Please ask for: Sian Eggington
Email: sian.eggington@terraquest.co.uk
Telephone: 0121 2341390
Our Ref: BR/248/20/PL
Your Ref:
Date: 23rd October 2020

Application for Planning Permission

Development: French doors with glass juliet balcony. Replacement of window and door with sliding patio door.
Location: The Gables, Flat 4 Norfolk Square Bognor Regis PO21 2JD

Block Plan - 4 The Gables, Bognor Regis

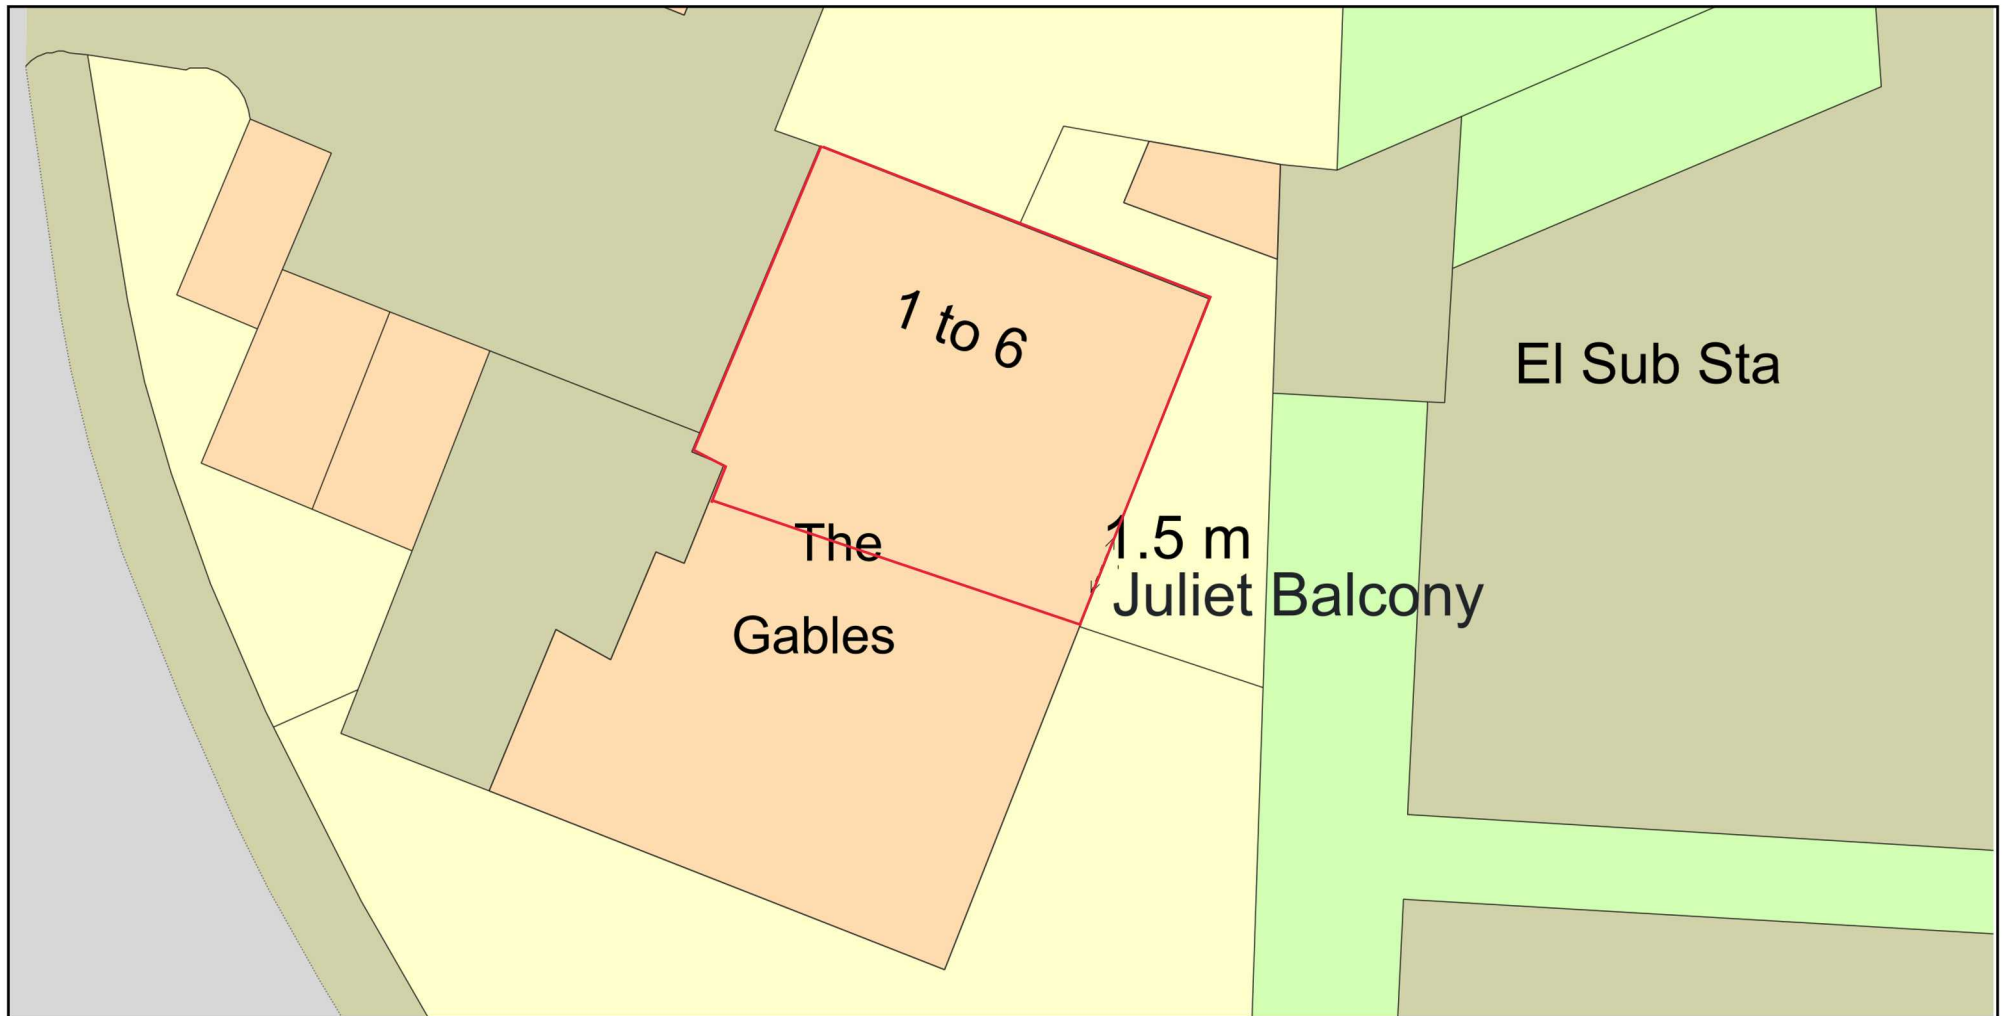
Block Plan: Please include a red outline on the block plan
